February 9, 2022

**RE: Widefield Water and Sanitation District (WWSD, District)
Booster 2 Pump Station Replacement
Site Development Plan – Comment Response**

LEGEND:

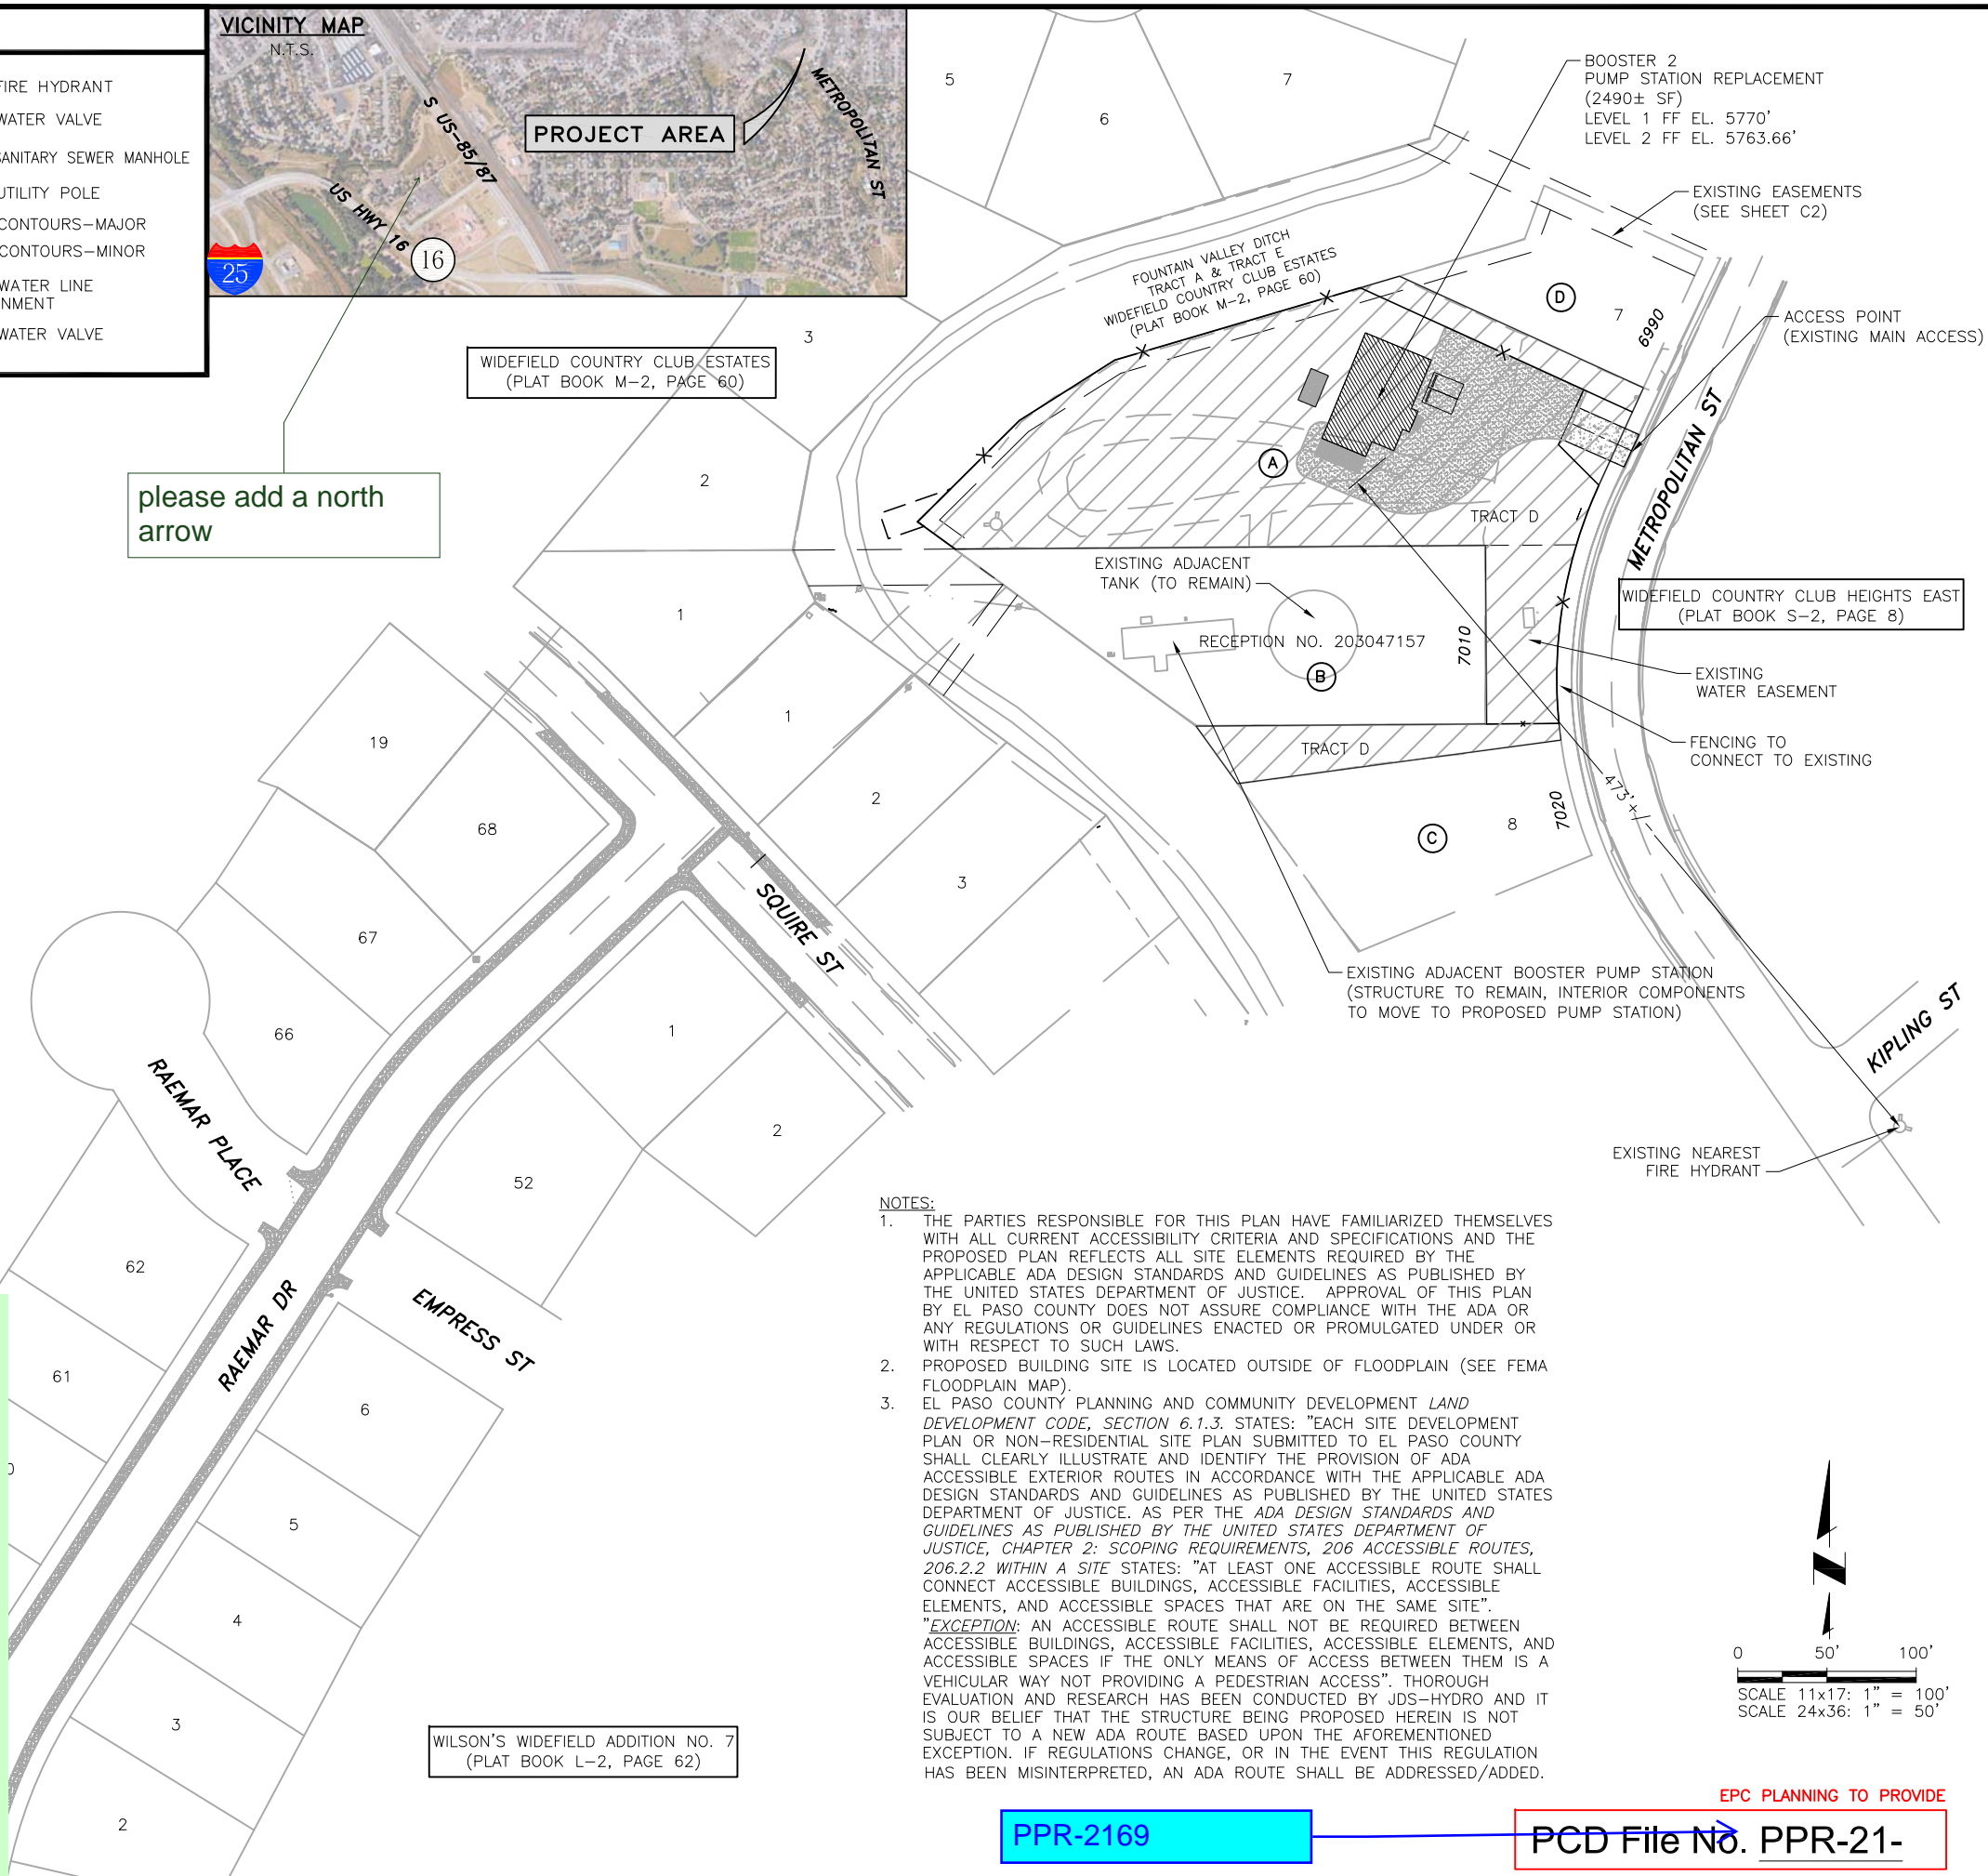
1. Site Development Plan (SDP) – please add the following:
 - Owner name, contact telephone number, and email for responsible party
 - Applicant name (if not owner), contact telephone number, and email for responsible party
 - Plan preparer name, telephone number, and email
 - Location and dimension of all property lines, rights-of-way, and all existing and proposed easements

- The footprint of all existing and proposed buildings
- Add North arrow to Vicinity Maps
- Please note any work within the public ROW requires a work-in-the-ROW permit
- Where is this sheet (reference callouts)

See resubmitted SDP Plans for additional information requested.
